Re: Site Plan Application – Design Brief
3700 Twin Falls

Urban Design Brief

Below is a list of responses to the urban design directions provided at the pre-consultation meetings with City staff.

SITE PLAN LEGEND:

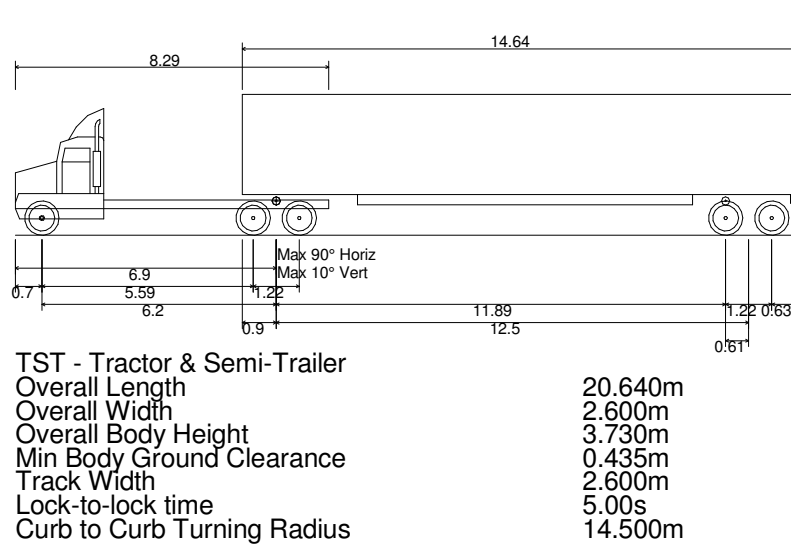
10. Consider shifting some of the parking spaces to establish a great landscape area along Leitrim and Gastops Street. This will help signify the building entrance and sense of arrival to the site. Understandably some stalls are needed for visitors but a few of the stalls in the front yard setback adjacent to Leitrim and a few along Gastops should be shifted giving a greater presence to the building entrance.

CSV Response: The parking along Letrim Road has been reduced to (8) spaces from (19) previously shown on drawing A100. Refer to updated drawing A100 issued for SPC, dated December 10, 2024.

40 YEAR TREE CANOPY PROJECTION

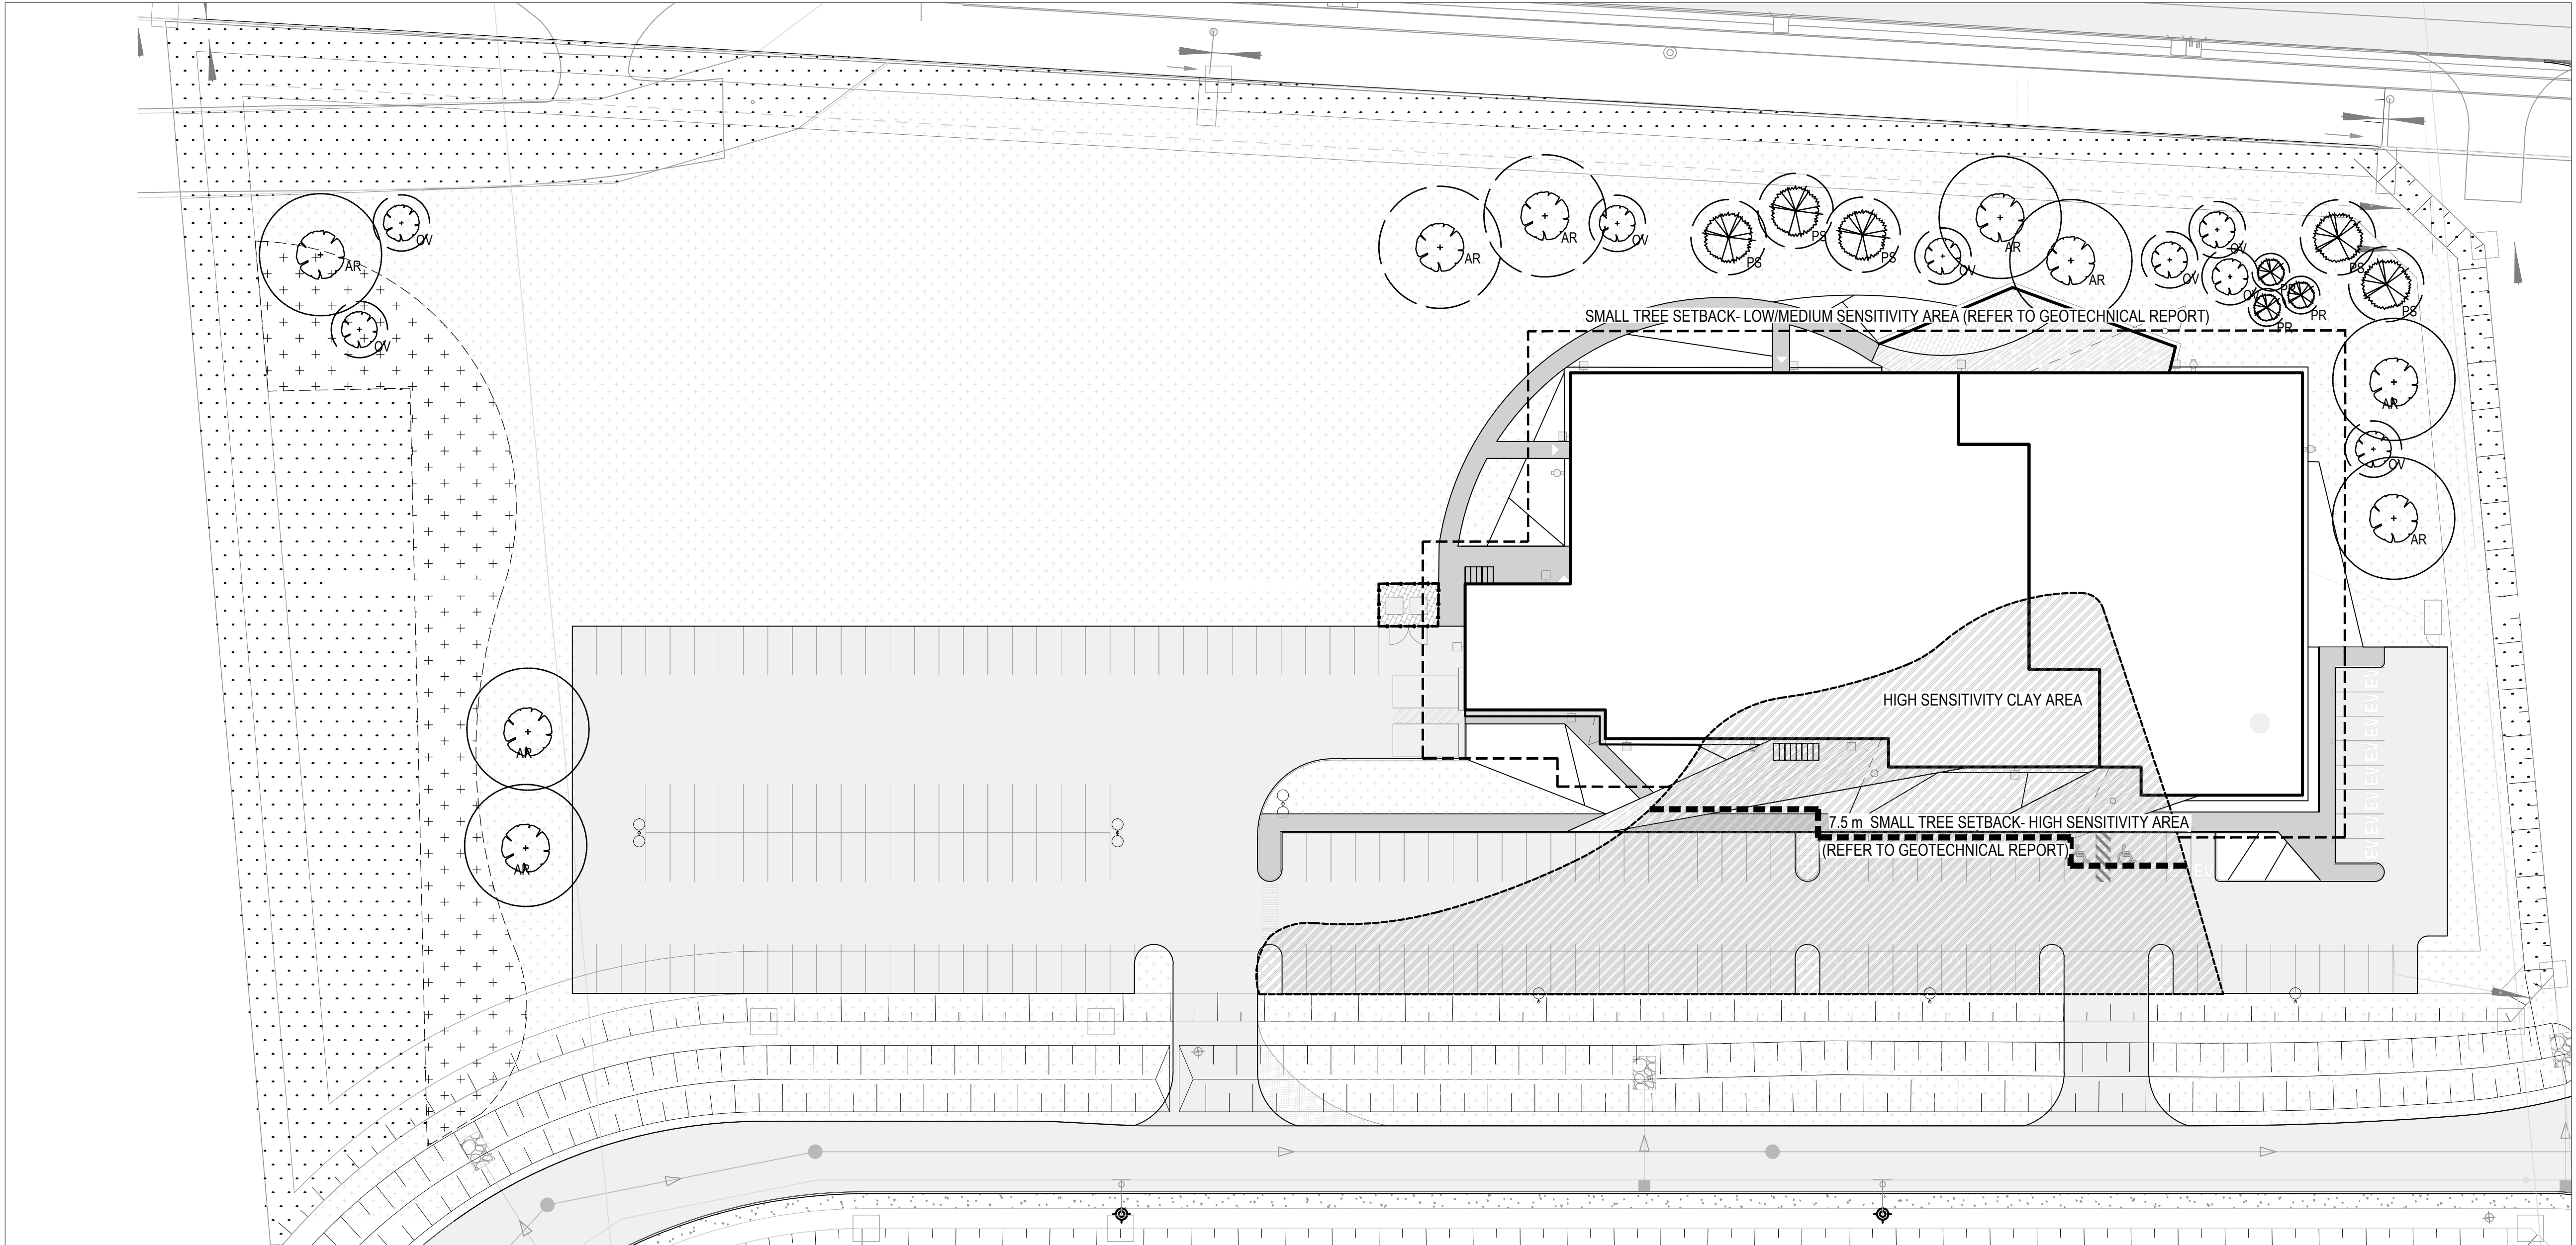
16. Please provide as many trees as possible, great opportunity along the Limebank Road frontage.

CSV Response: Trees have been provided along Limebank Road, refer to Landscape Plan attached.
